CITY OF ALBUQUERQUE

RE: **Durango at the Trails (File: C09D012)**
Drainage Report for Units 1 to 4
Engineer's Stamp Date 10-24-2014

GENERAL NOTES

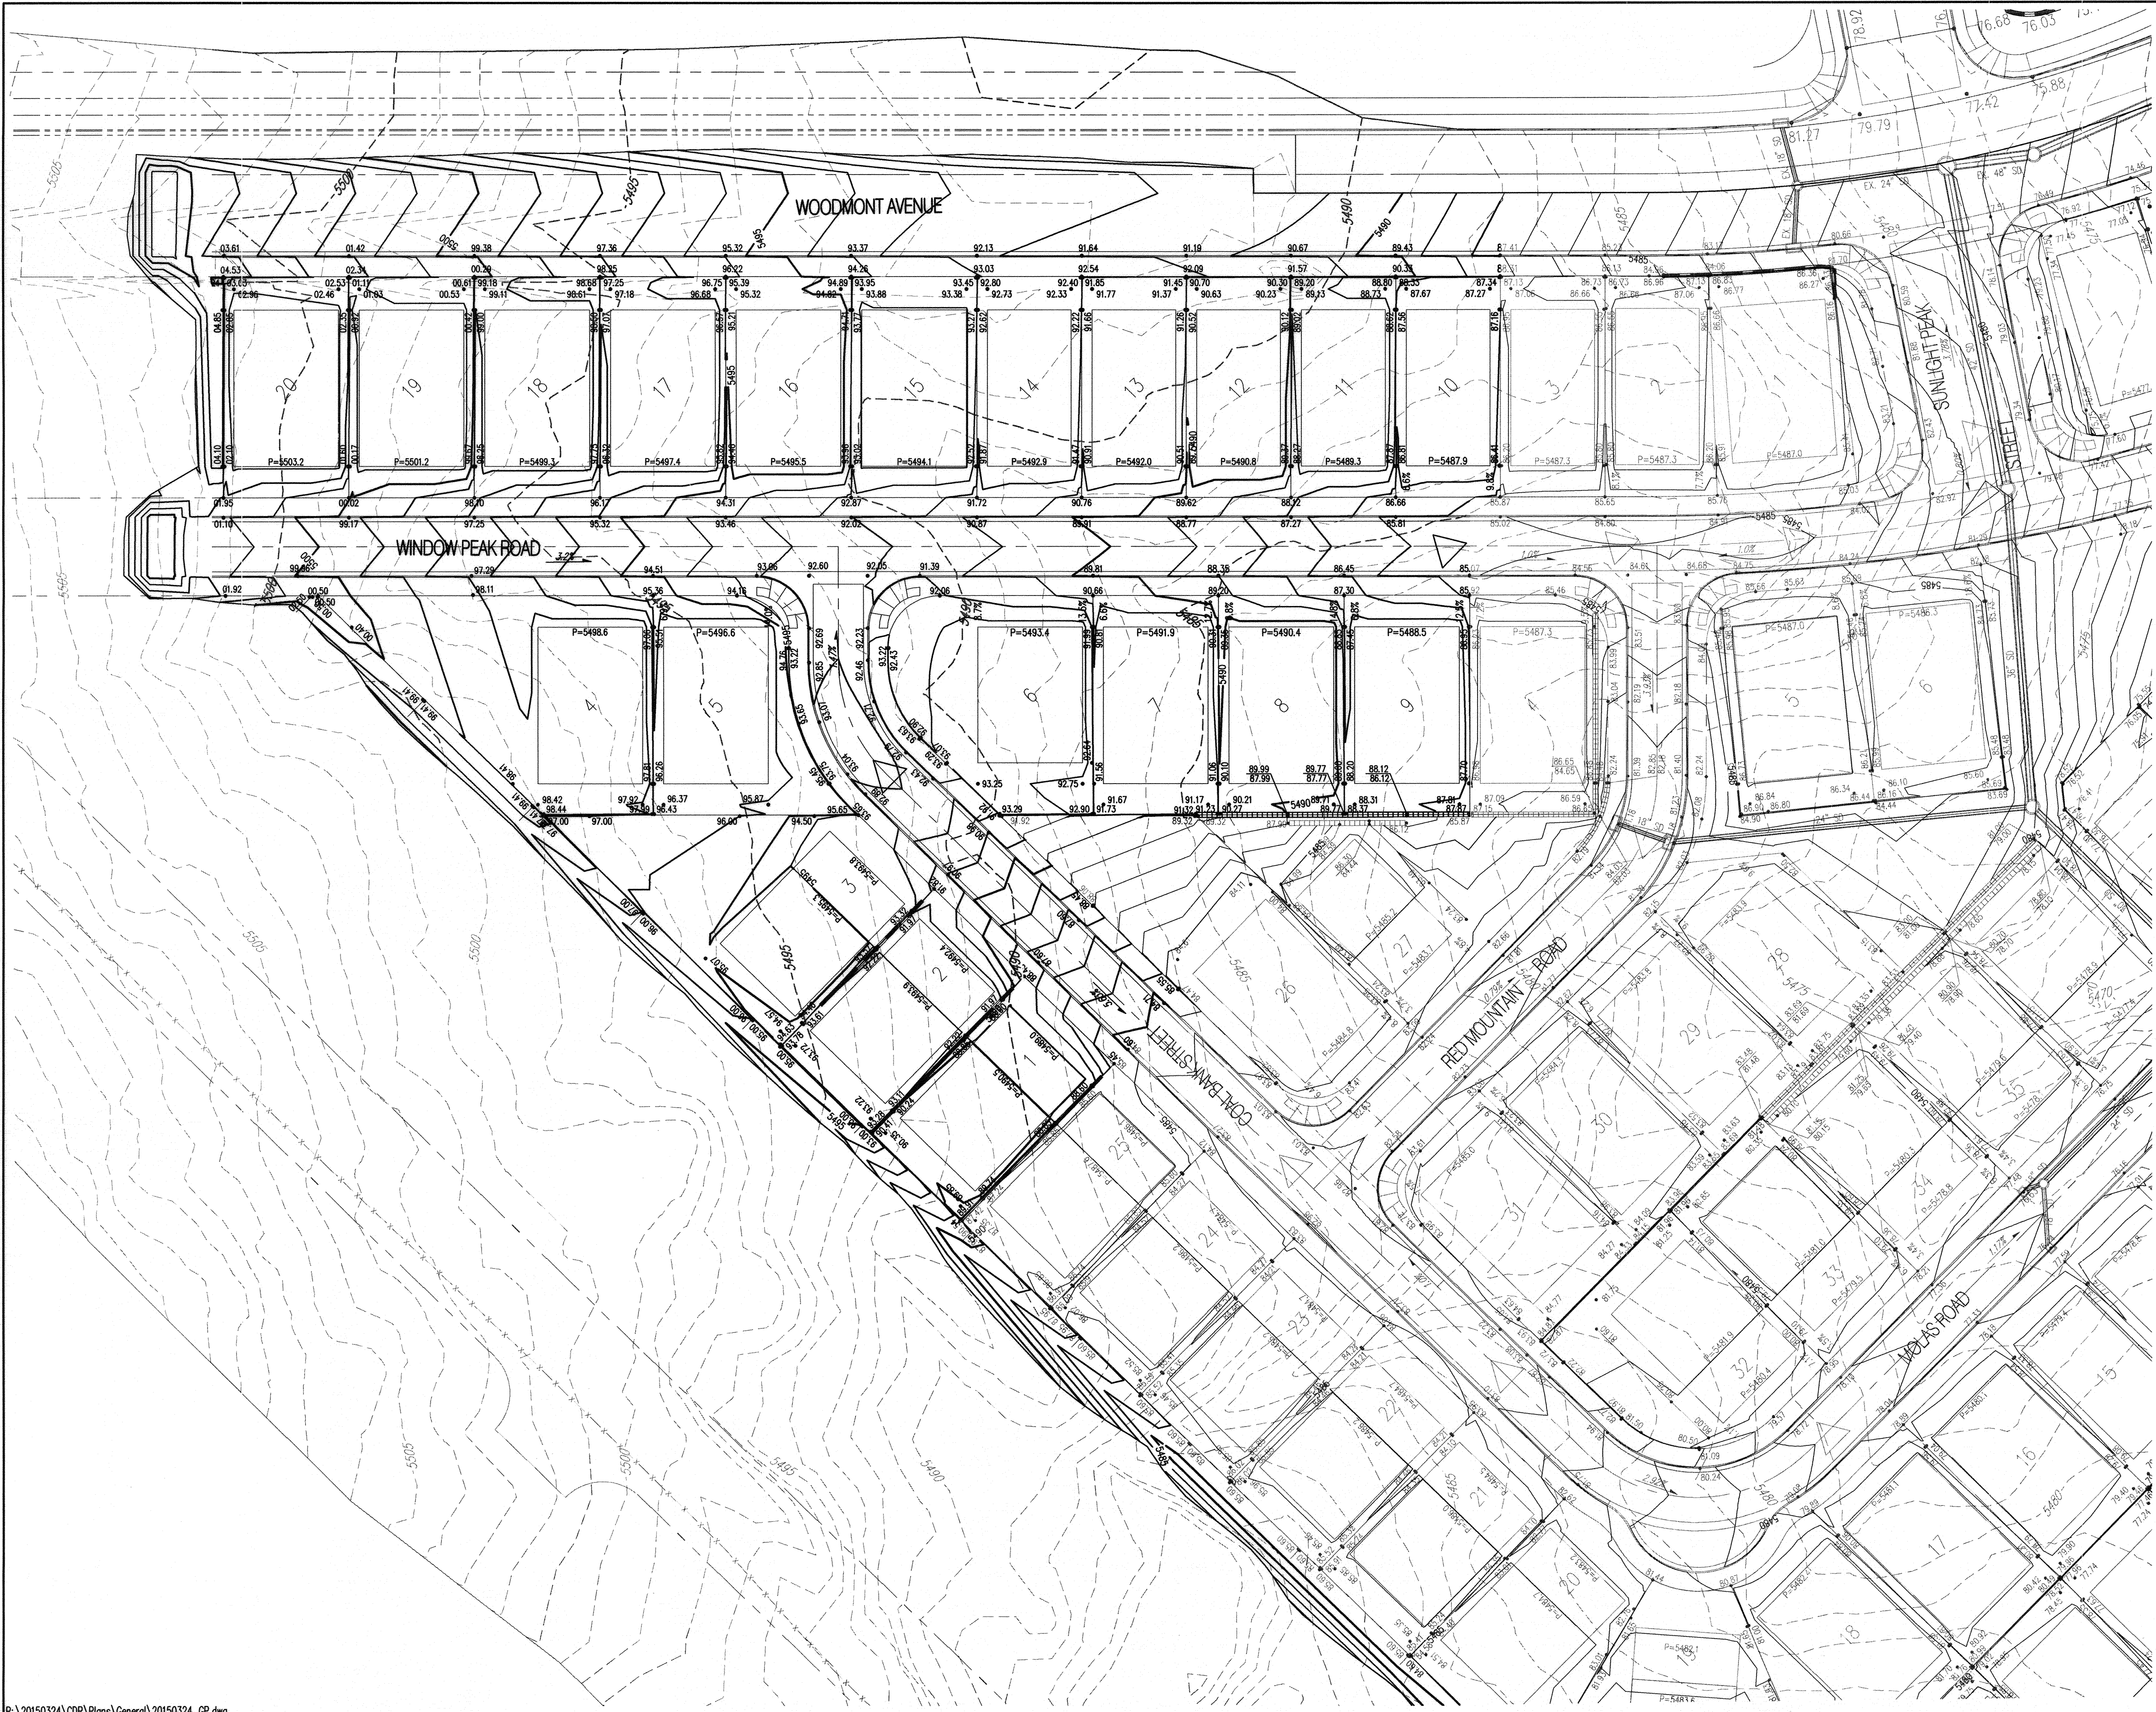
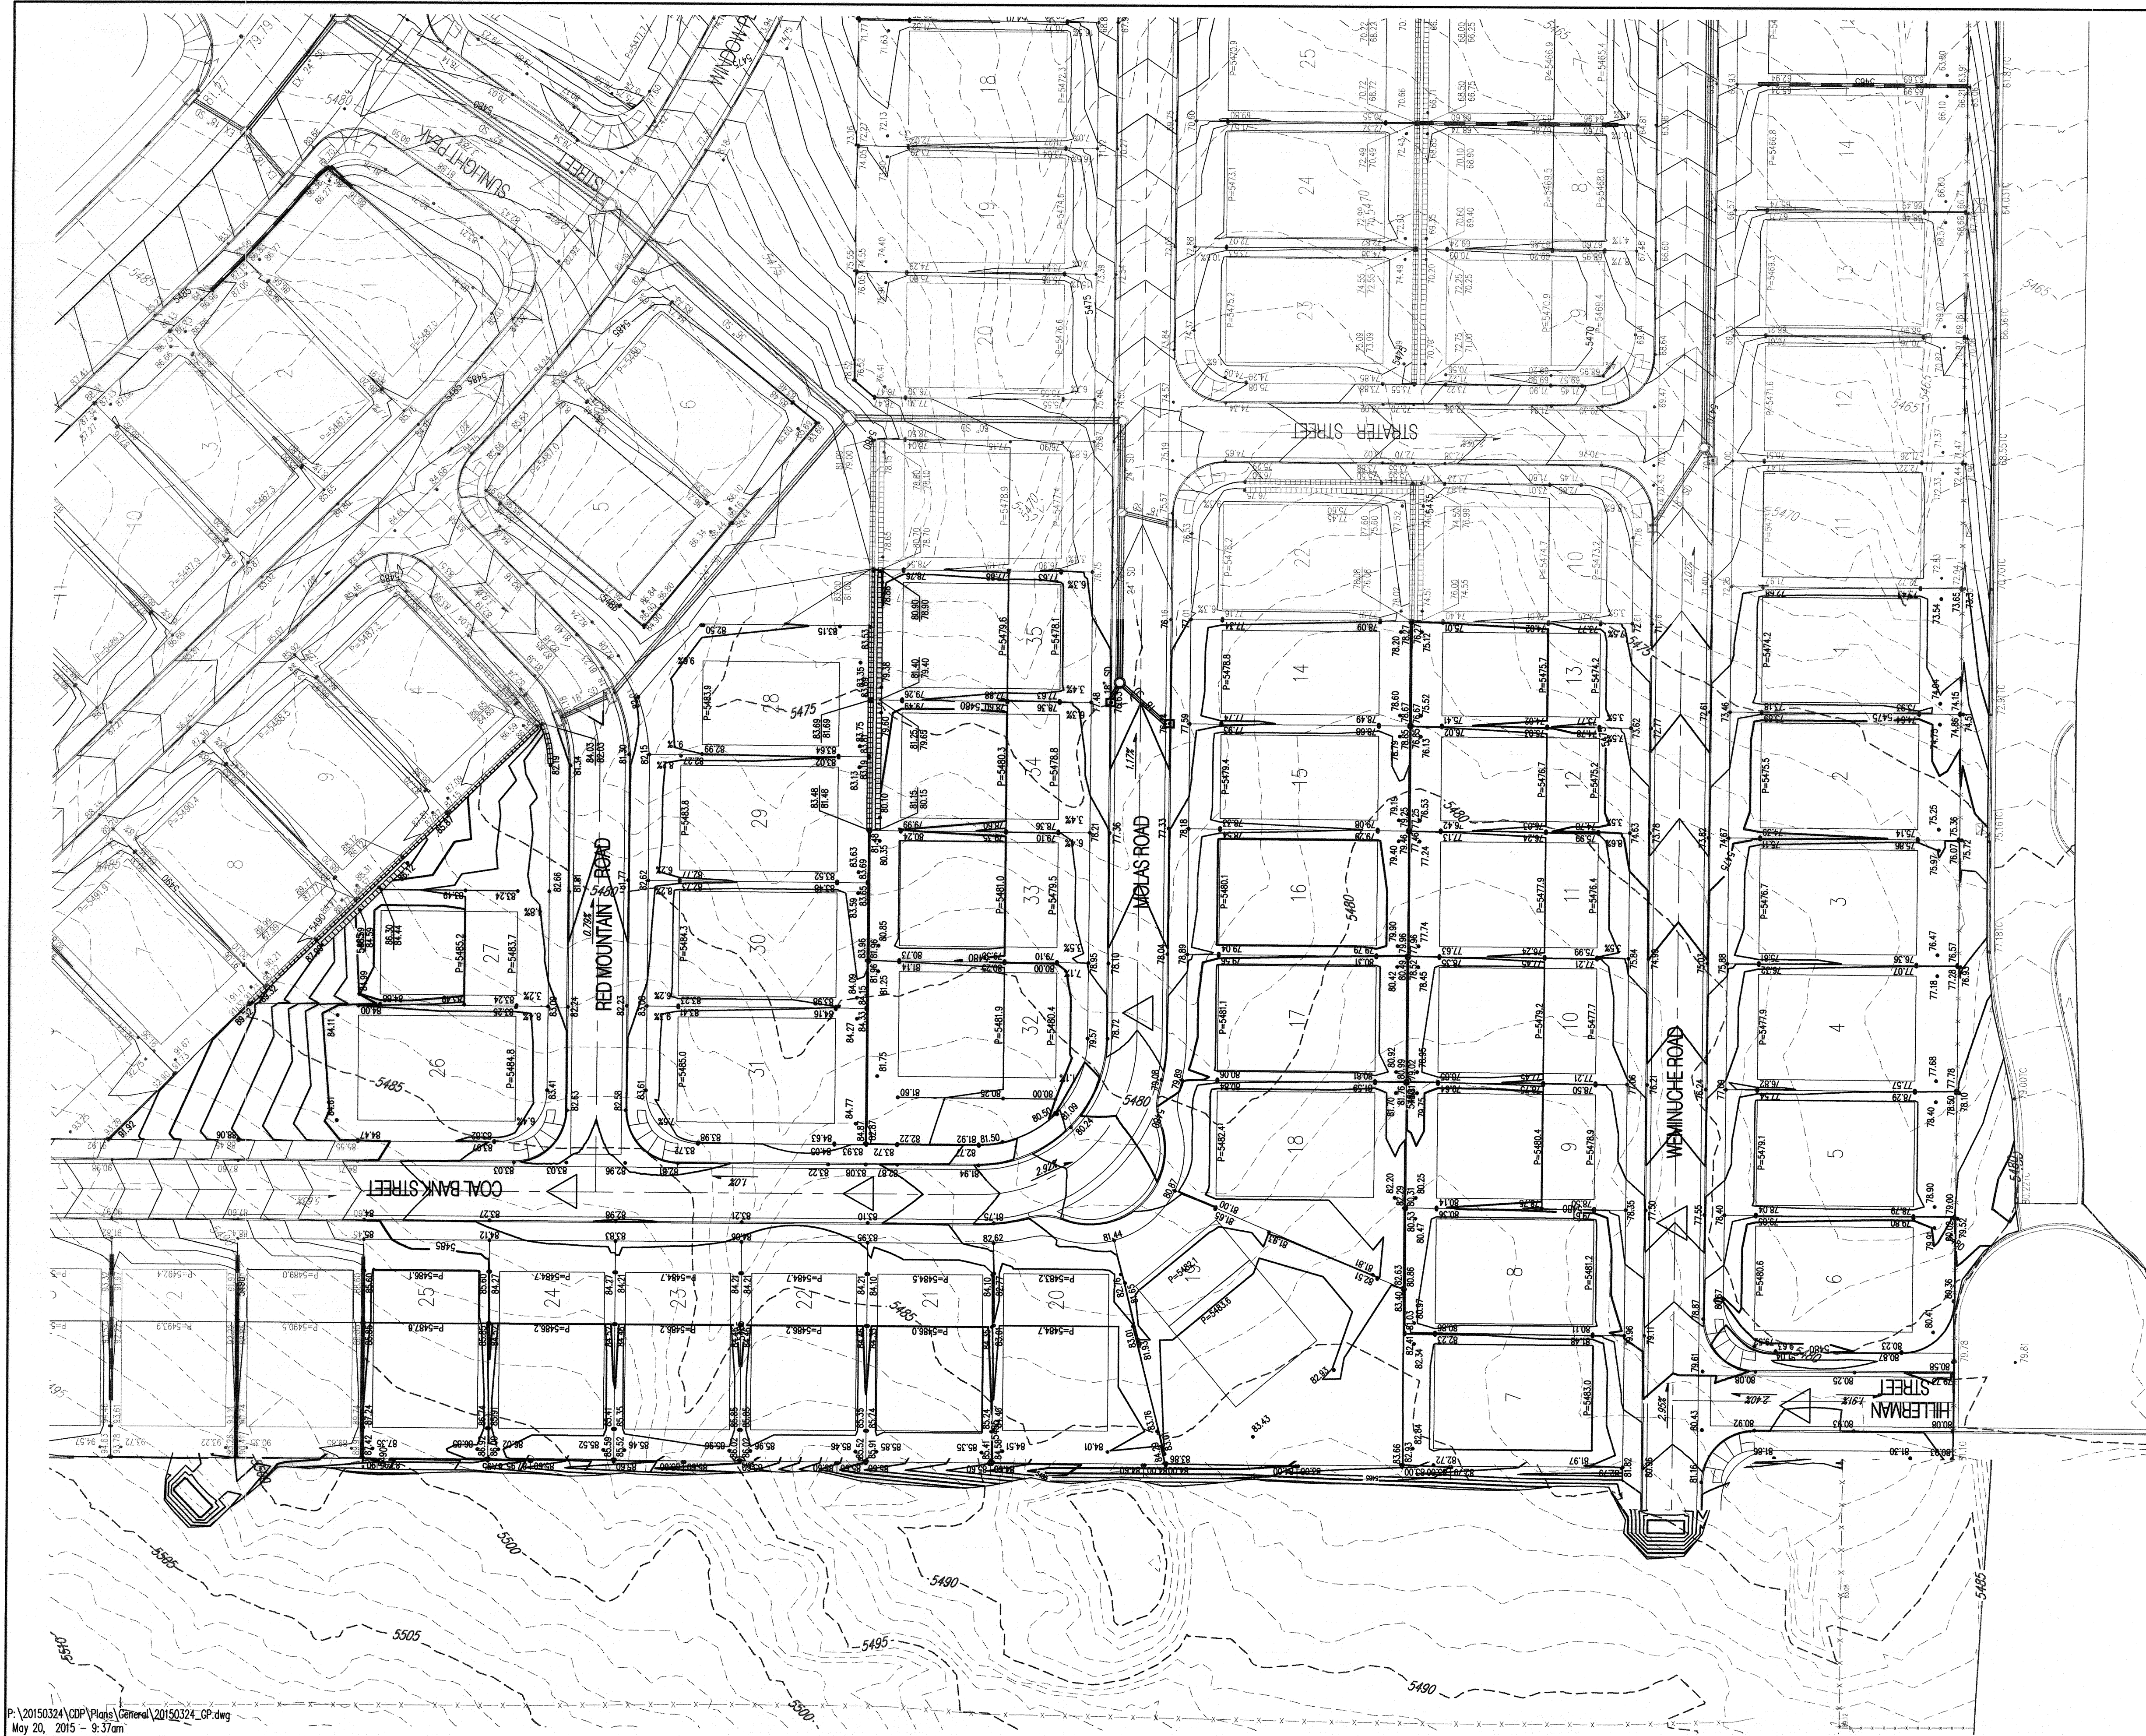
1. Units 1 thru 4 are to be phased. Provide an interim grading plan for each phase, showing sediment ponds and tie slopes.
2. Provide revised grading plan showing recent changes. Grades and retaining walls will be checked after this plan is submitted.
3. Revise I.L list with for separate line items for each run/size of pipe.
